Phone: 0300 123 6780
Email: developeras@lancashire.gov.uk
Your ref: 3/2025/0760
Our ref: 3/2025/0760/HDC/KW
Date: 17 October 2025

Location: 28 Longridge Road Chipping PR3 2QD
Proposal: Demolition of existing single storey garage and kitchen. Proposed two storey side extension and single storey rear extension with associated alterations.
Grid Ref: 362442 443076

With regard to your consultation letter dated 9 October 2025, I have the following comments to make based on all the information provided by the applicant to date.

PROPOSED SITE PLAN

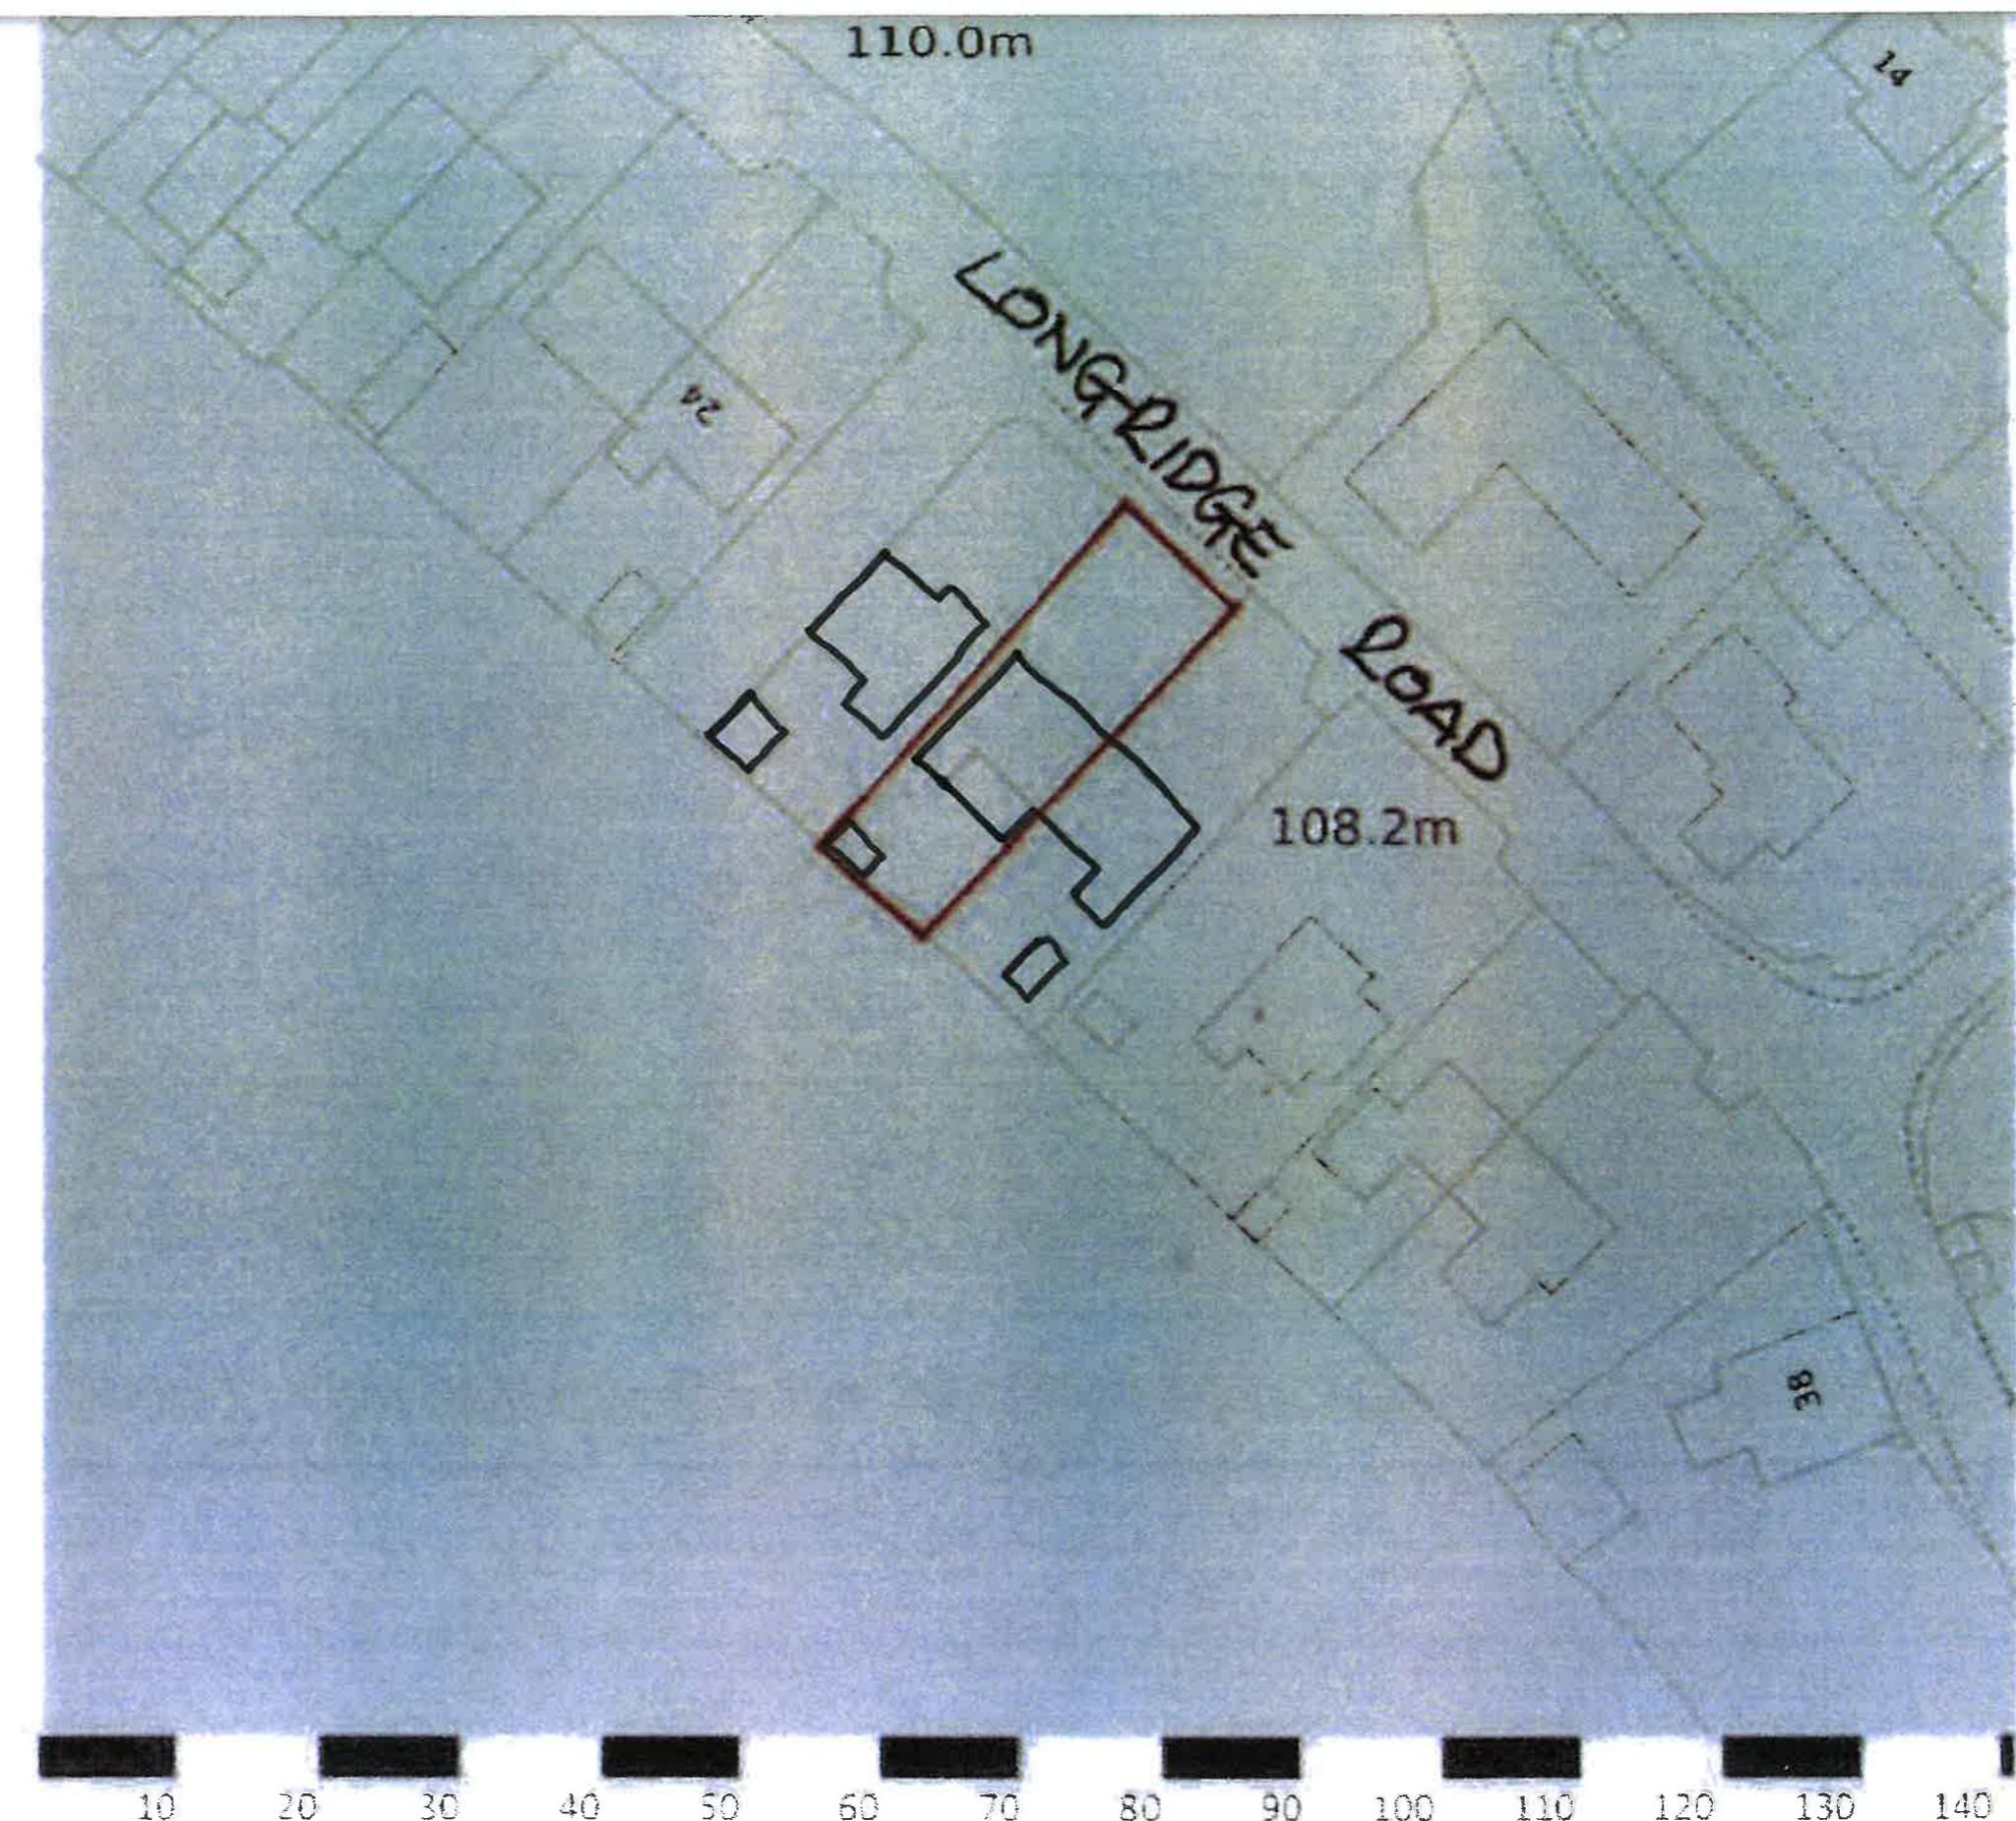
The LHA are aware that the dwelling will continue to be accessed off Longridge Road which is a C classified road subject to a 20mph speed limit. A 3-bedroom dwelling should provide at least 2 off-street parking spaces to ensure a negligible impact on highway safety and highway capacity within the immediate vicinity of the site. These spaces should measure at least 5m in length and 2.4m wide, where they are adjacent to a fence or similar obstruction an additional width of 0.6m should be provided. If the driveway has shared pedestrian access an additional 0.8m should also be provided.

Whilst the proposal will remove the existing garage, the LHA is of the opinion that 2 off-street parking spaces can be provided within the site, as such the LHA has no objections to the proposal.
